Final Plat Drawings_v1.pdf Markup Summary 8-29-2022

FALCON MEADOWS AT BENT GRASS FILING NO. 4

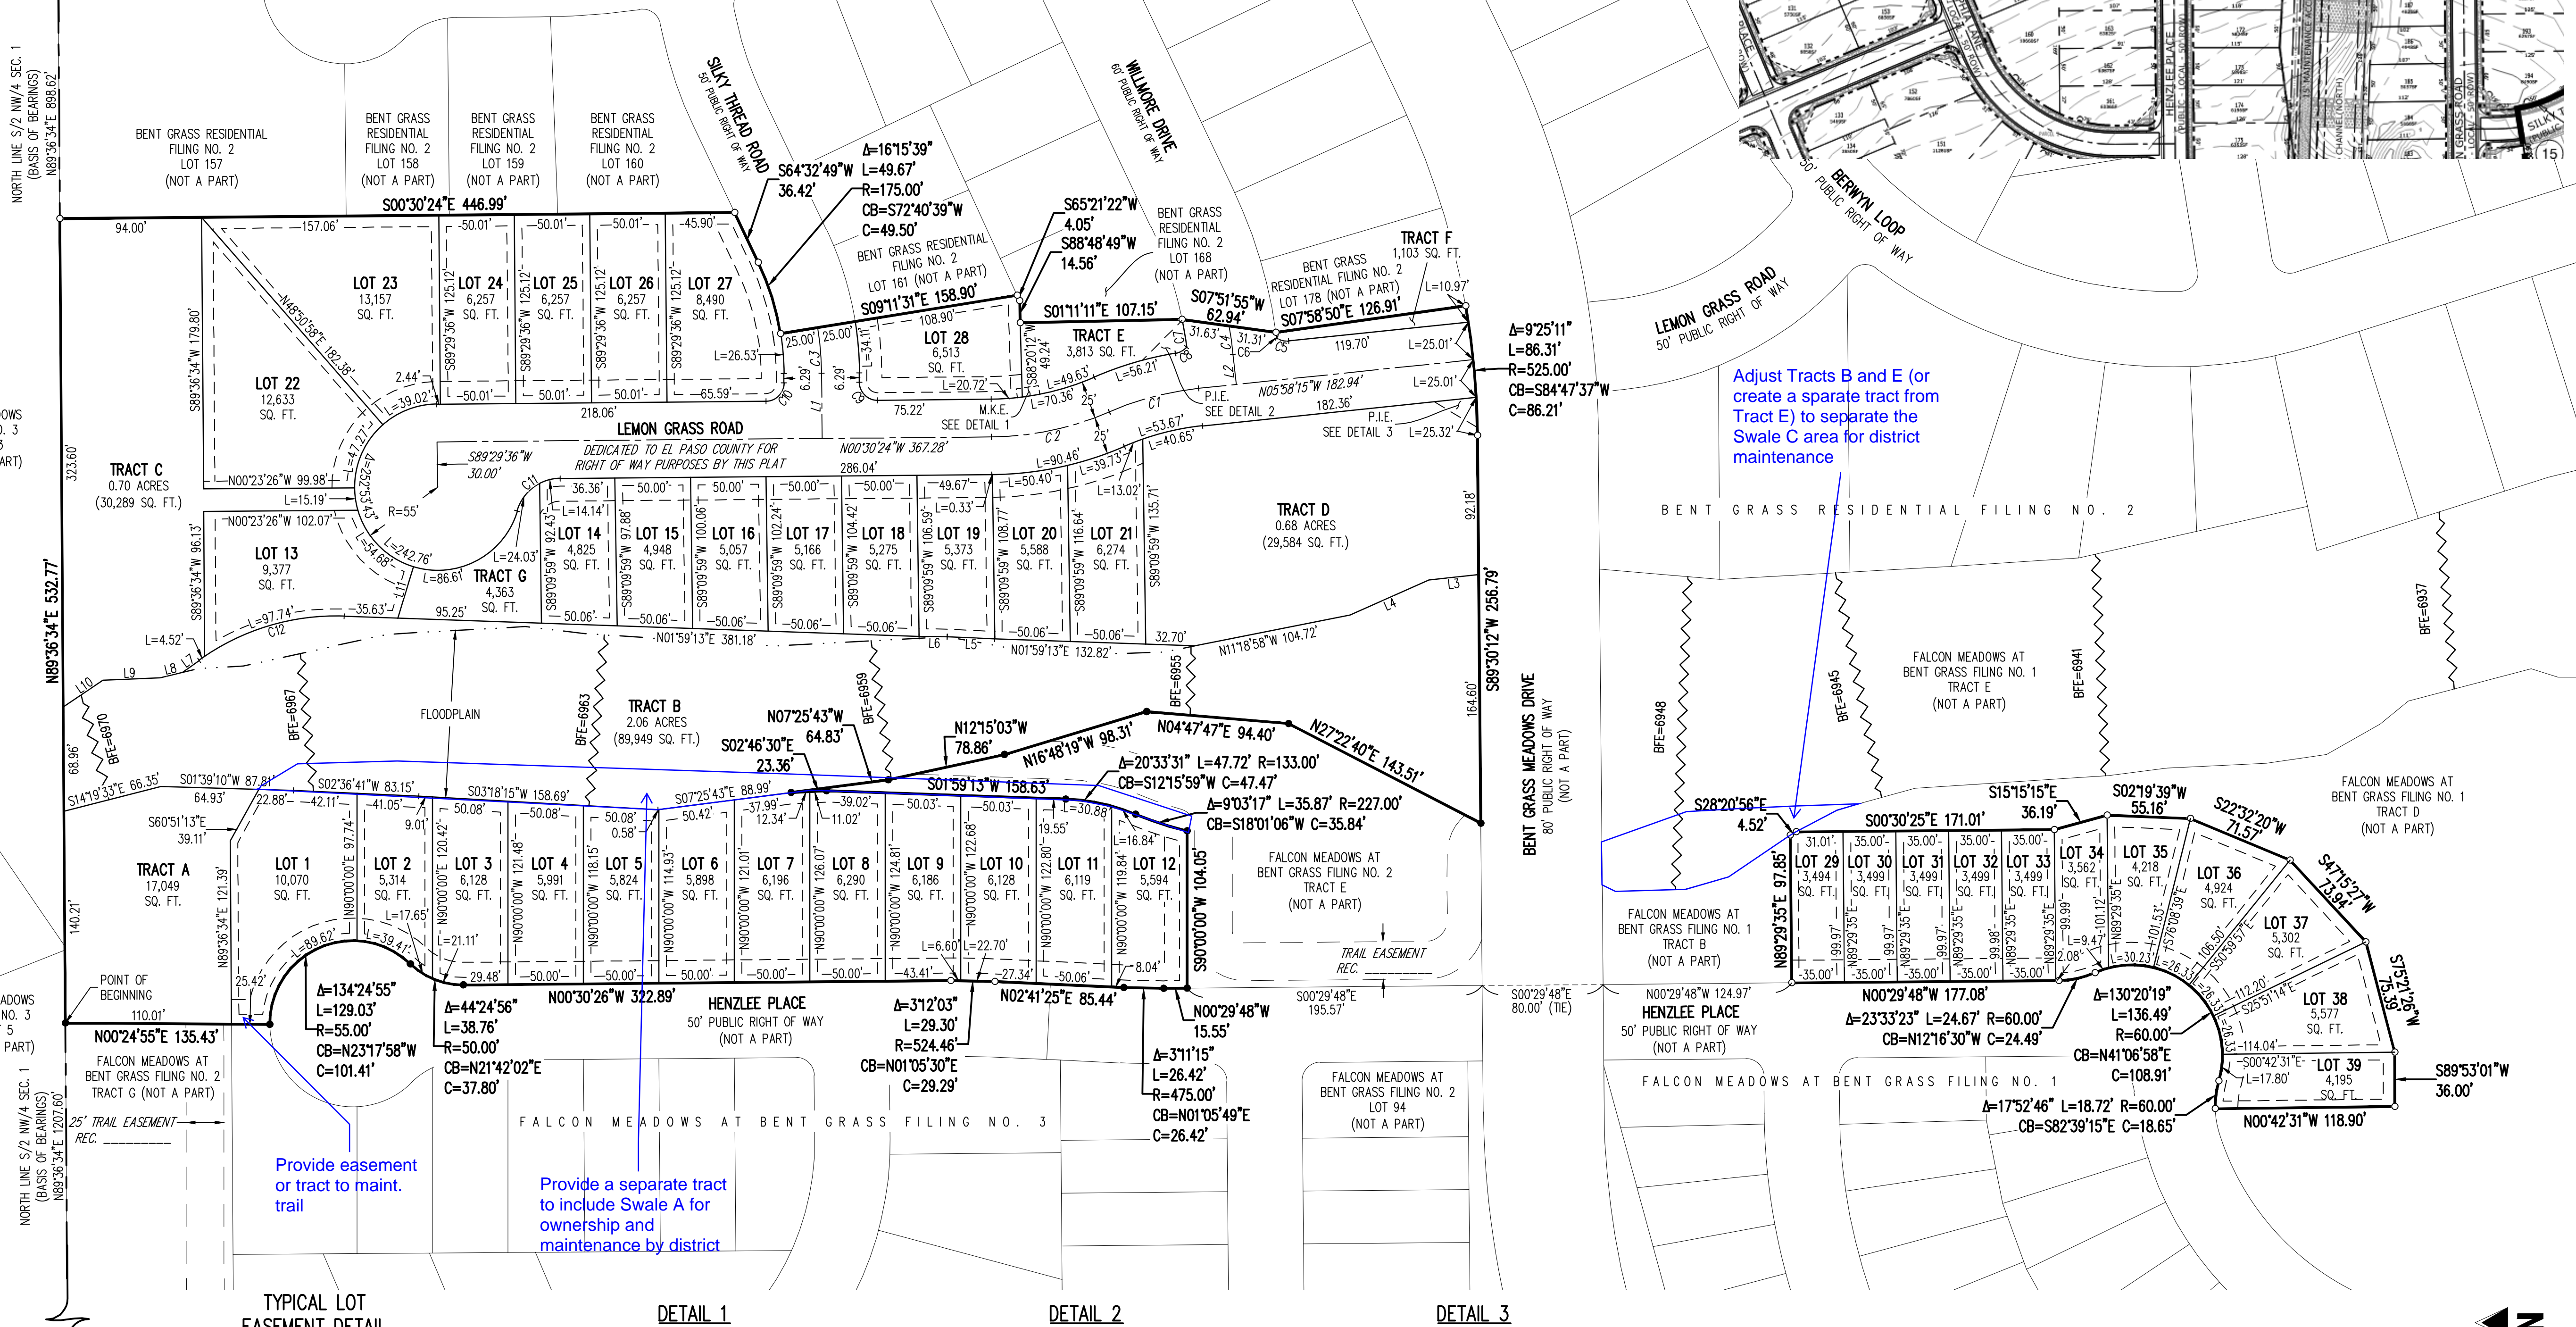
please see PUD for the maintenance access road surface and labeling

Provide easement or tract to maint. trail

Provide a separate tract to include Swale A for ownership and maintenance by district

Adjust Tracts B and E (or create a sparate tract from Tract E) to separate the Swale C area for district maintenance
